From: Finlay Gardner
Sent: 01 July 2019 12:58
To: Planning.Responses <Planning.Responses@arun.gov.uk>
Subject: FW: Application AW/156/19/T

Your application AW/156/19/T is currently set to be refused following comments from the Arboriculturist as attached.

Ref 1

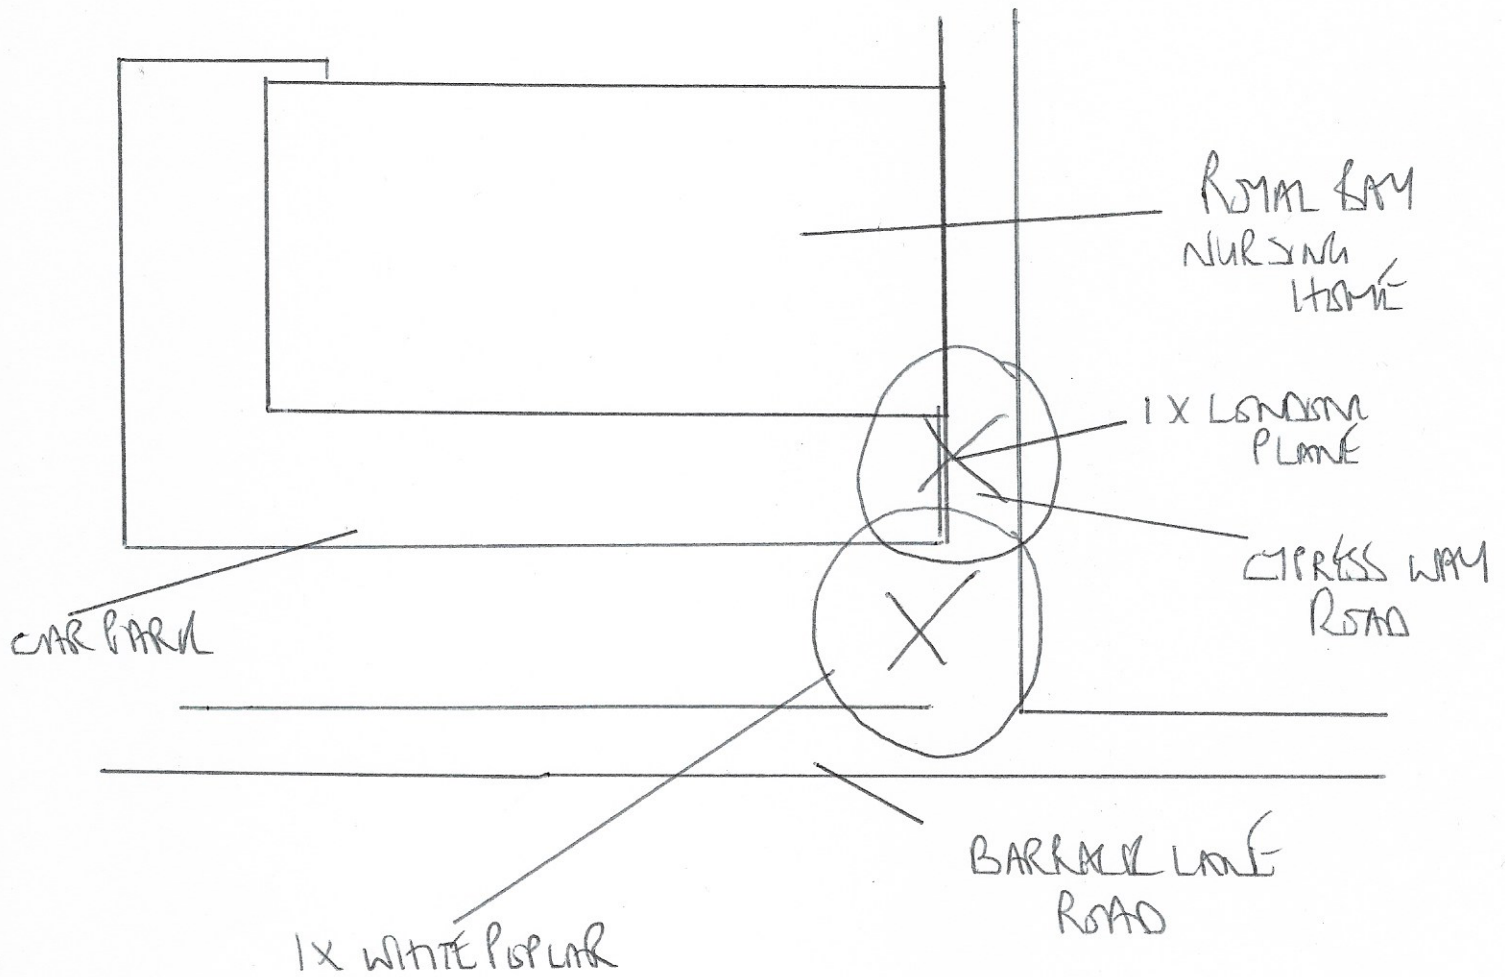
We would like to go ahead with the recommendations received for the application at Royal bay nursing home. Please could you submit this to the application so we can then go ahead with the work.

Please let me know if the advisory comments are acceptable and I can amend the description to be in line with the recommendations and write them it up to recommend approval.
